re: Geotechnical Review of Grading and Site Servicing Plans
Proposed Residential Development
3055 Richmond Road - Ottawa

file: PG6187-MEMO.02

- Grading Plan – 4 Storey Low-Rise Apartment Building – 3055 Richmond Road – Drawing G1 – Revision 9 dated March 13, 2023
- Site Servicing Plan – 4 Storey Low-Rise Apartment Building – 3055 Richmond Road – Drawing S1 – Revision 9 dated March 13, 2023

CLIENT:
OTTAWA
ONTARIO
PROJECT:
4 STOREY LOW-RISE
APARTMENT BUILDING
3055 RICHMOND ROAD
OTTAWA, ON K2B 6S6

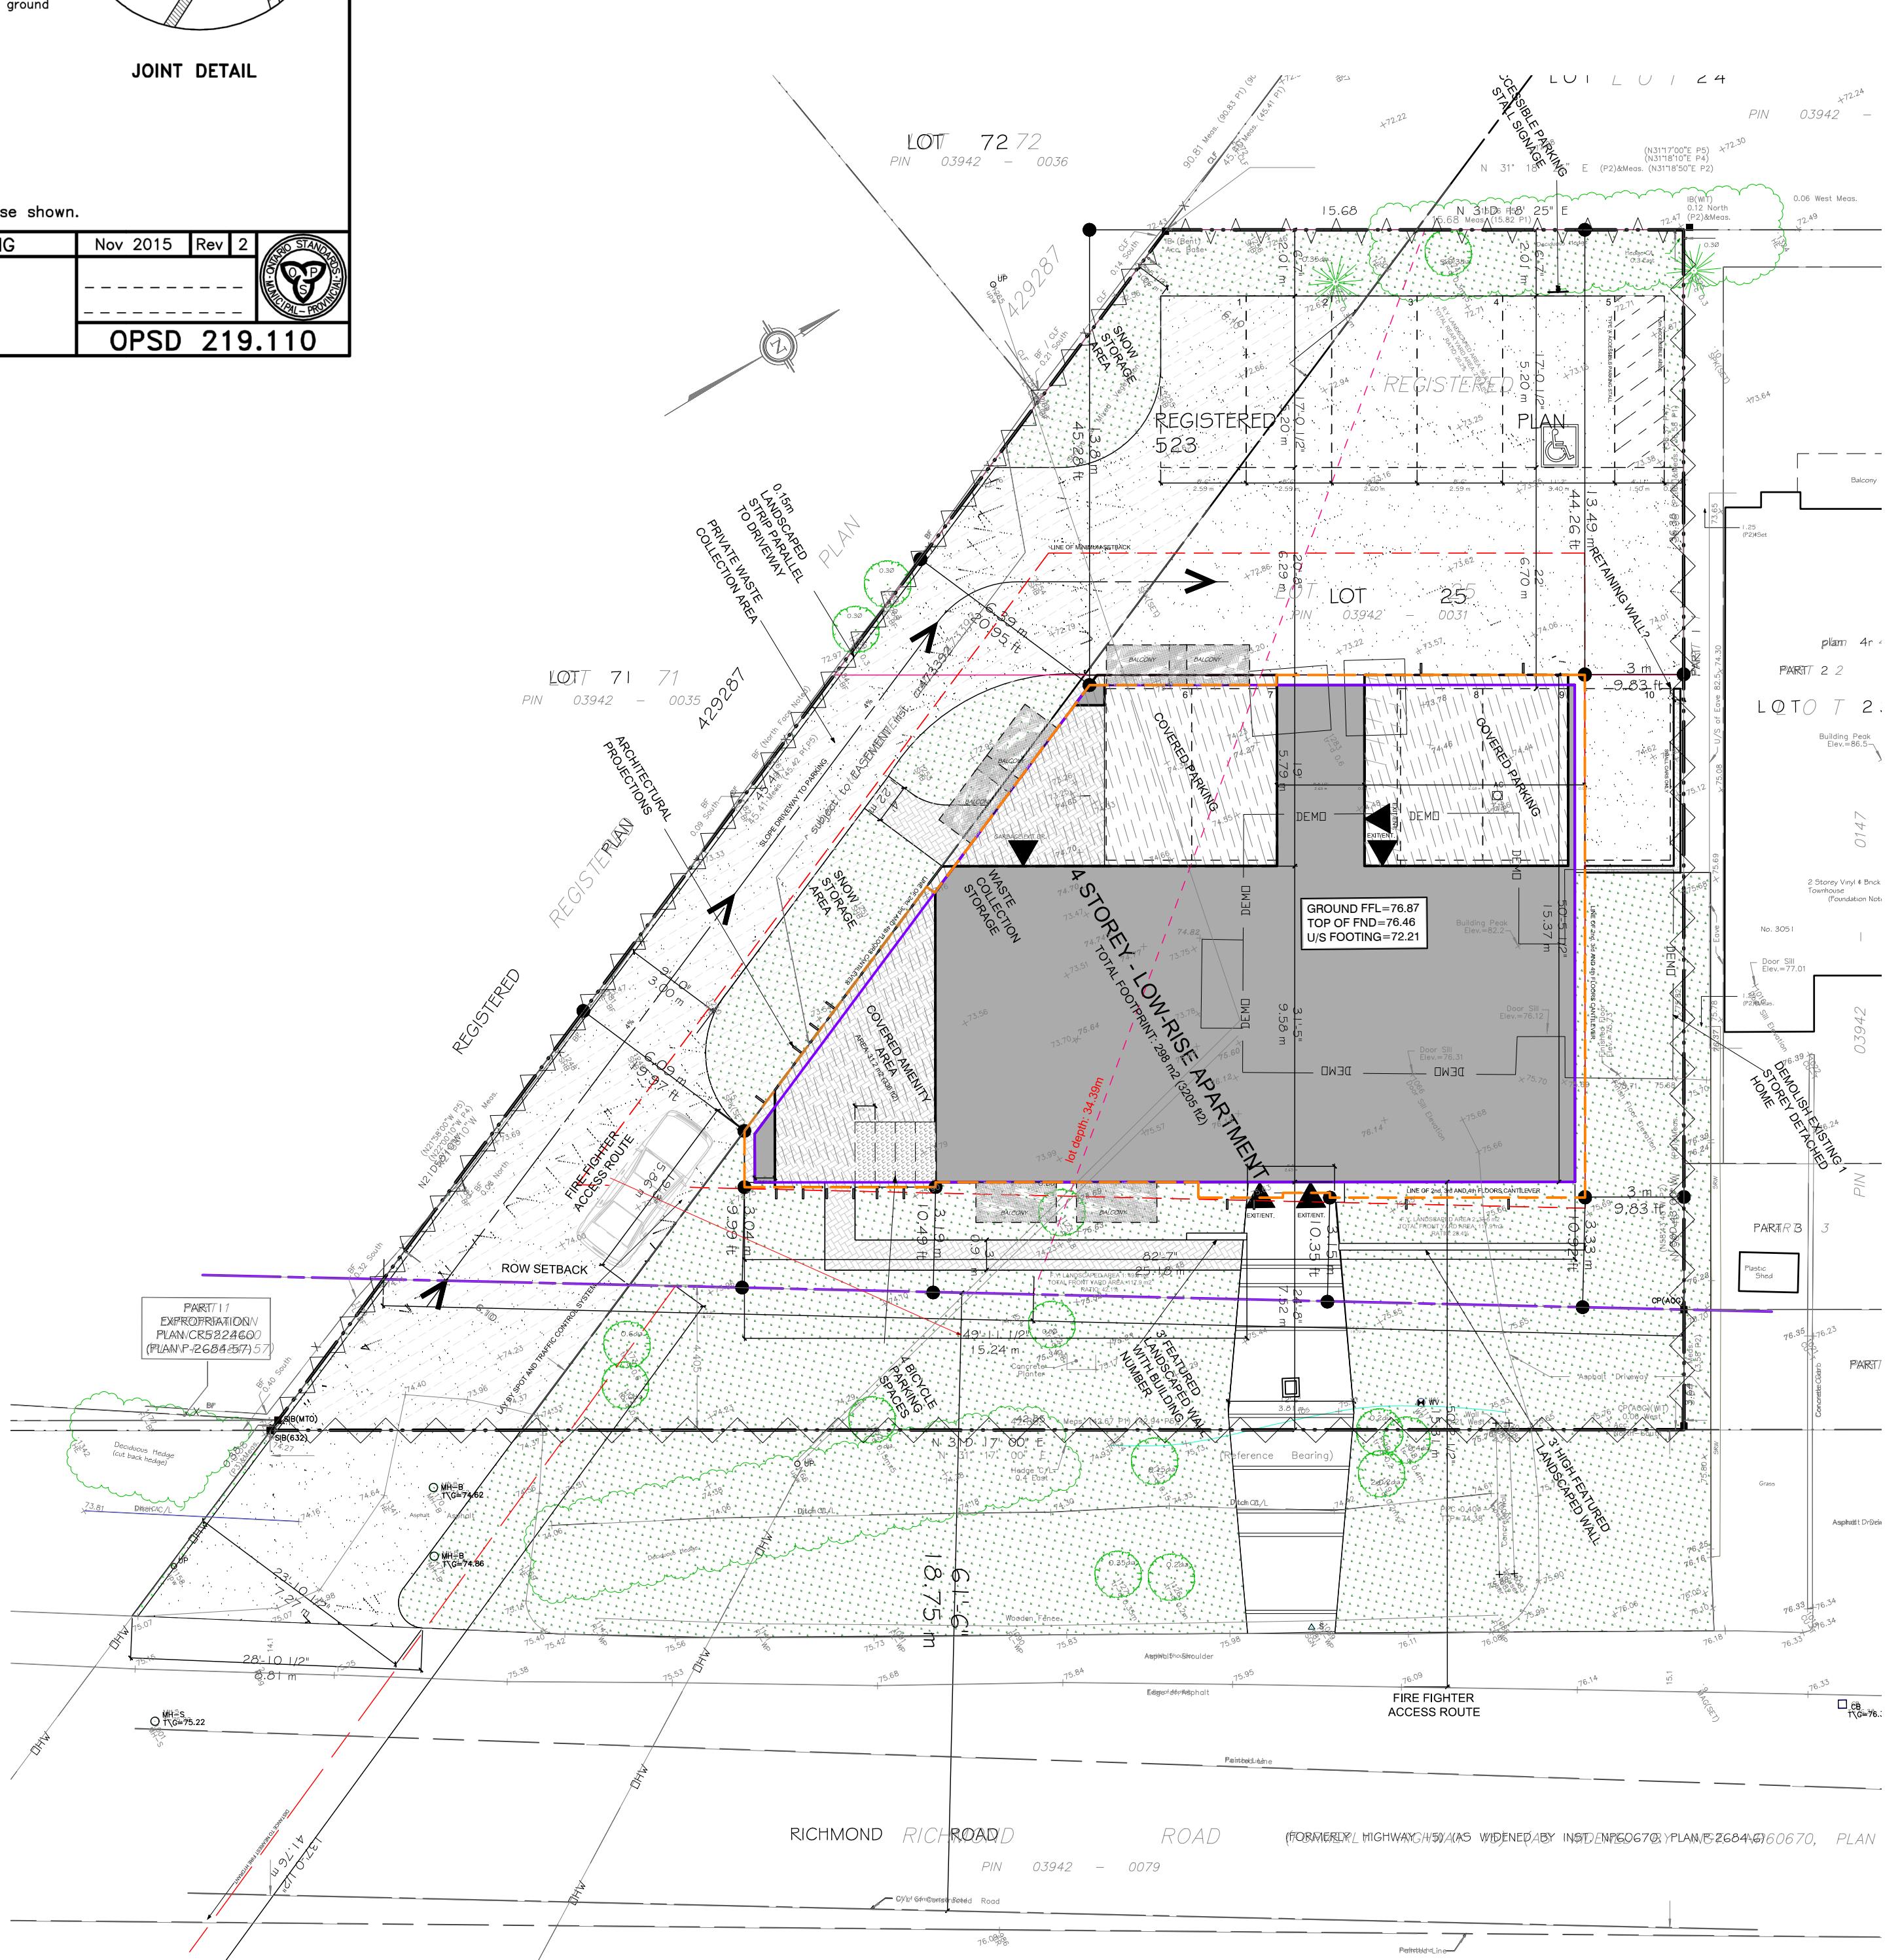
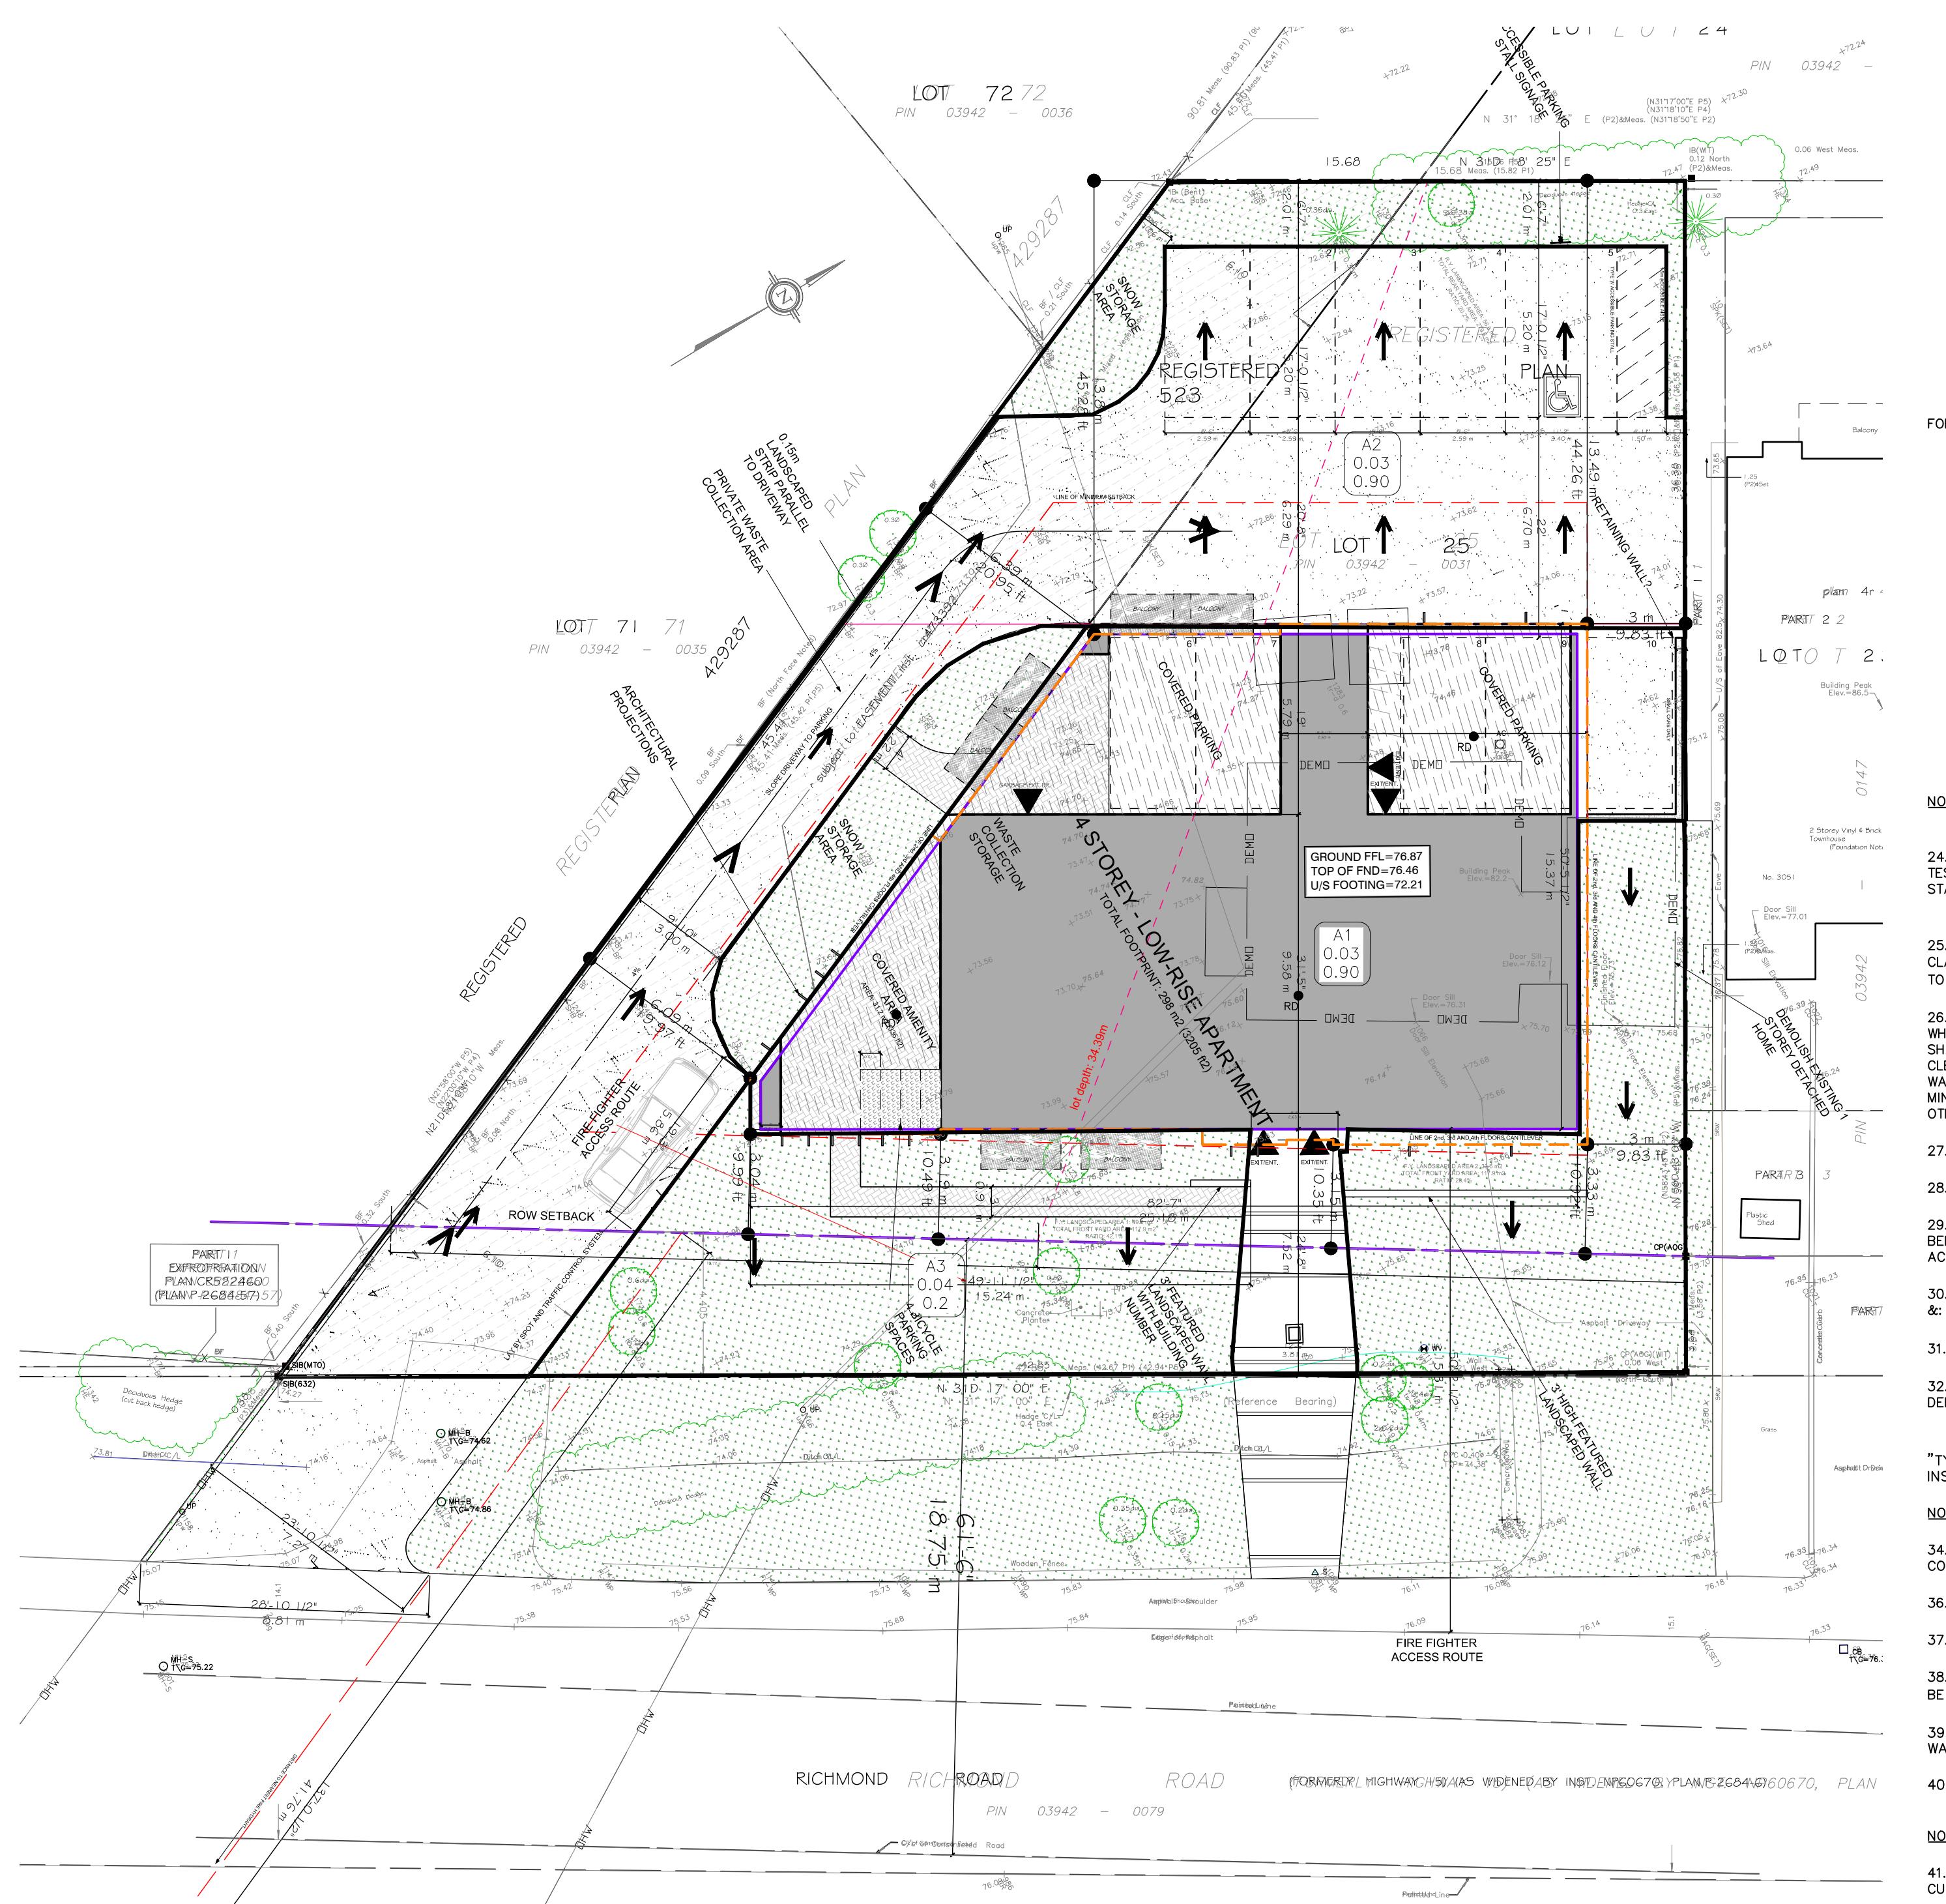
Based on Paterson's review of the aforementioned drawings, the proposed finish grading for the subject development is considered acceptable from a geotechnical perspective and lightweight fill (LWF) is not required. A lateral support zone of 1.5H:1V or greater, as well as adequate frost protection, is provided for the proposed footings and service pipes. Therefore, the site servicing design is considered acceptable from a geotechnical perspective.
